M3 J9 ISH2 2nd AUG_PT2

Okay. Thank you, ladies and gentlemen. Think we're all back. So I will resume this hearing at 1135 and continue with our discussion about air quality. Um, item two on the air quality agenda is construction phase impacts. Um, so a question to Winchester City Council. In your local impact report, you state that there's a commitment to the Section 61 Control of Pollution Act 1974 and prior consent is welcomed and early dialogue is requested with so that the Council can be satisfied that mitigation during construction delivers and will provide the level of mitigation assumed within Chapter 11.

DRAWING TITLE  
FIGURE 2.5 - THE SCHEME: TEMPORARY TRAFFIC DIVERSION ROUTES  
APFP REGULATIONS 5(2)(a)  
SHEET 4 OF 12  
DOCUMENT REFERENCE 6.2

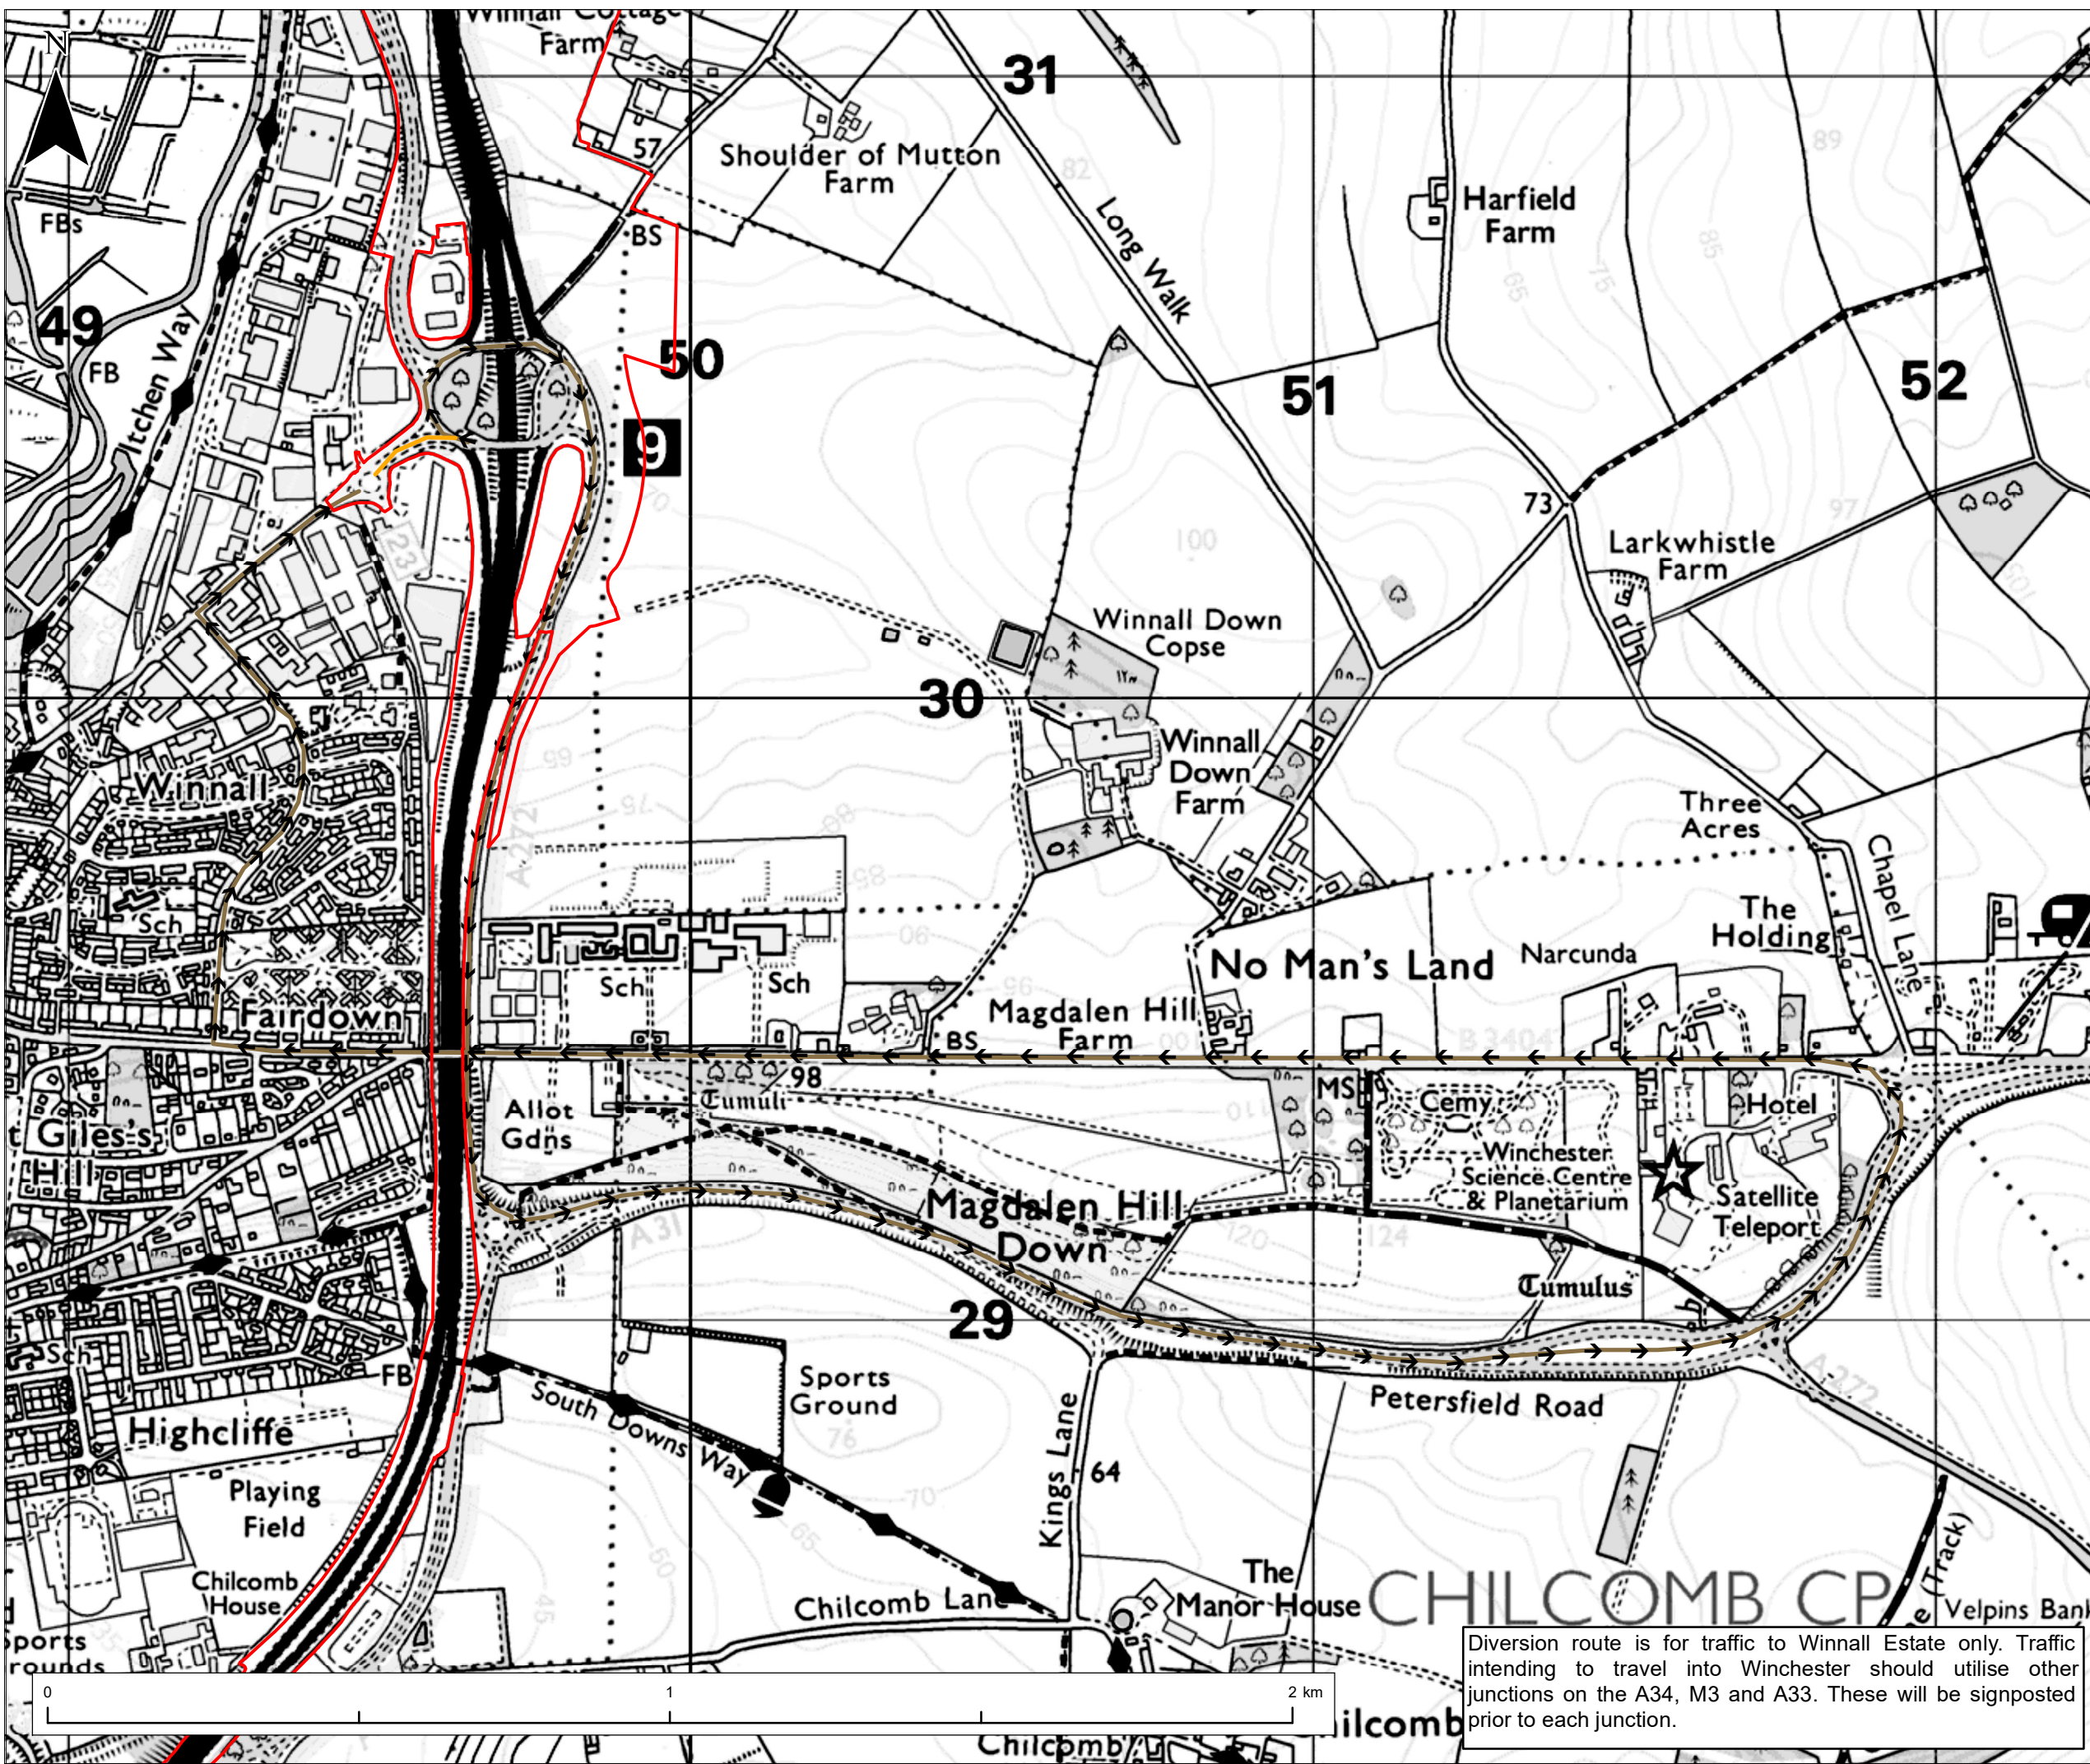
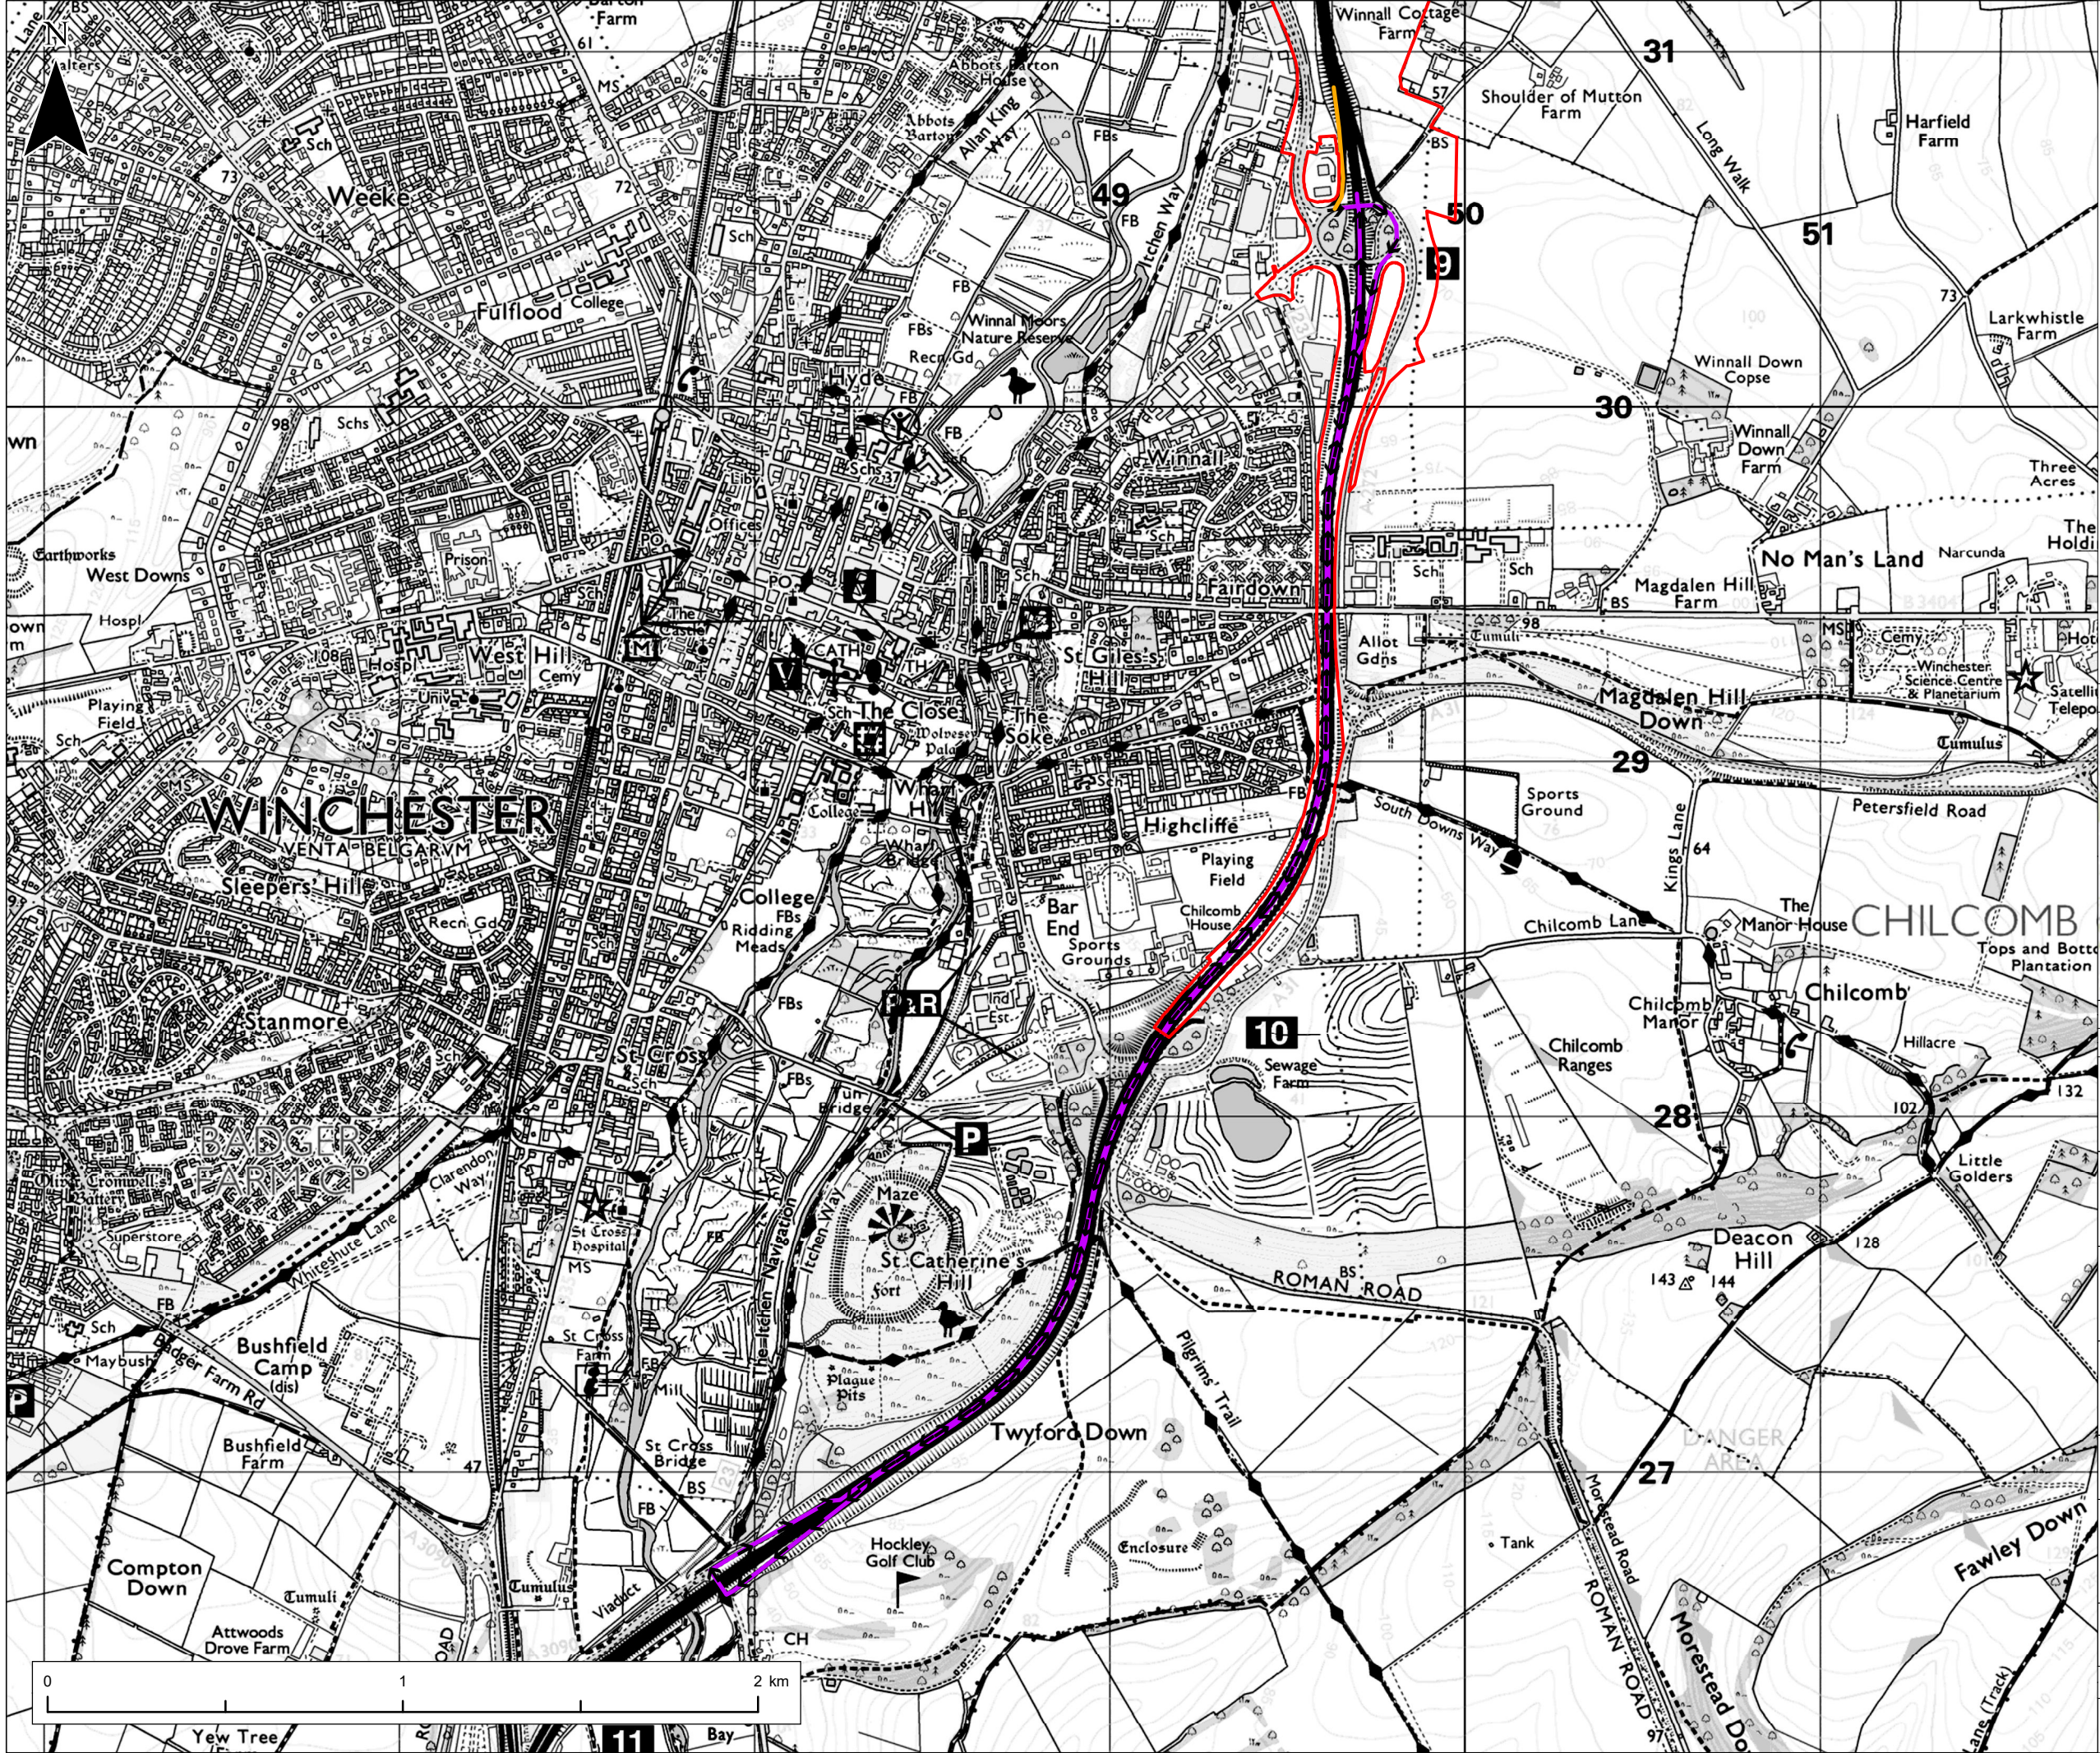
So so on the understand, we're talking about equality in more general terms. Um, we've already raised our concerns about potential adverse effects within the, um, during the construction phase for both resulting from traffic diversions and potentially in the days of Google and similar other things, the voluntary rerouting that people perform due to congestion. And that's of concern during the construction phase. Um, we've noted the applicant's comments, um, on our, our 102 page 72 of the applicant's response to relevant representations.

But we don't feel that satisfactorily answers our concerns. So still no reference to air quality impacts within a detailed diversion assessment methodology methodology. And we'd request that such criteria is listed and considered and reviewed as part of that consideration.

We had filters at Winchester City. We do have some concerns in relation to the methodology with the the assumption of or diversions will be followed in the modeling methodology performed, which in reality I think we would all agree it's not the case and particular reference, we'd just like some more work done on that. And in reference to the consideration of the including in a diversion assessment, some reference to air quality which still doesn't exist.

So we'd like that to be more formally acknowledged. The overall methodology, yes, but we do have we have no issue with it in a high level, but we do have issue with that that detail in terms of the way they've assessed the divergence and the impacts and particular reference to a potential daytime diversions and and congestion and acknowledge that will be try to be limited. And the assessment demonstrates nighttime closures.

But I think we need to see more work on the bits where that won't be the case and more discussion and assessment of that, sir.

both through the sort of the main construction period when the northbound on slip is closed and the potential for diverted flows then. But we've looked at that and really because that northbound on slip is not heavily trafficked, that kind of redistribution of flows doesn't lead to a risk of air quality impacts. You then have the sort of the closure diversions and closure routes discussion that we've we've touched upon. But again, there's the sort of the overnight closures etcetera, aren't considered likely to lead to air quality impacts because we're looking at sort of the annual air quality conditions and these occasional overnight closures and diversions aren't considered a risk from that that regard.

Yeah. Katherine Tracy for the applicant. Happy to continue to have the dialogue as part of the statement of Common ground and and flesh it out outside of this process, the hearing. Um, but in terms of the diversionary routes, um, they will, as we explained yesterday, subject to some sort of emergency closures, will be overnight or extended weekend closures, limited number of them during the construction period. The only long term closure is the M3 junction nine on the slip.

Um, and that has been modeled to and the modeling suggests that actually the number of vehicles that we use that won't generate significant impacts on, on the traffic network that would lead to any significant air quality impacts across the network. Um, however, we can work to flesh out that response if it's not currently to the satisfaction of Winchester City Council in terms of diversion routes and the joys of taking people on whichever route that the satnav considers is appropriate.

That is not that's an endemic problem that every traffic scheme and including, you know, Winchester local closures and things will have. So we can have a discussion about that. But I'm not entirely sure that that's within the bounds of the developer to to fix. We will be monitoring diversion routes that we put in place. Um, drivers and alike tend to stick to them now. Think they've learned the errors of their ways with satnav. Um, but that it is possible during monitoring for additional traffic management measures to be put in place.
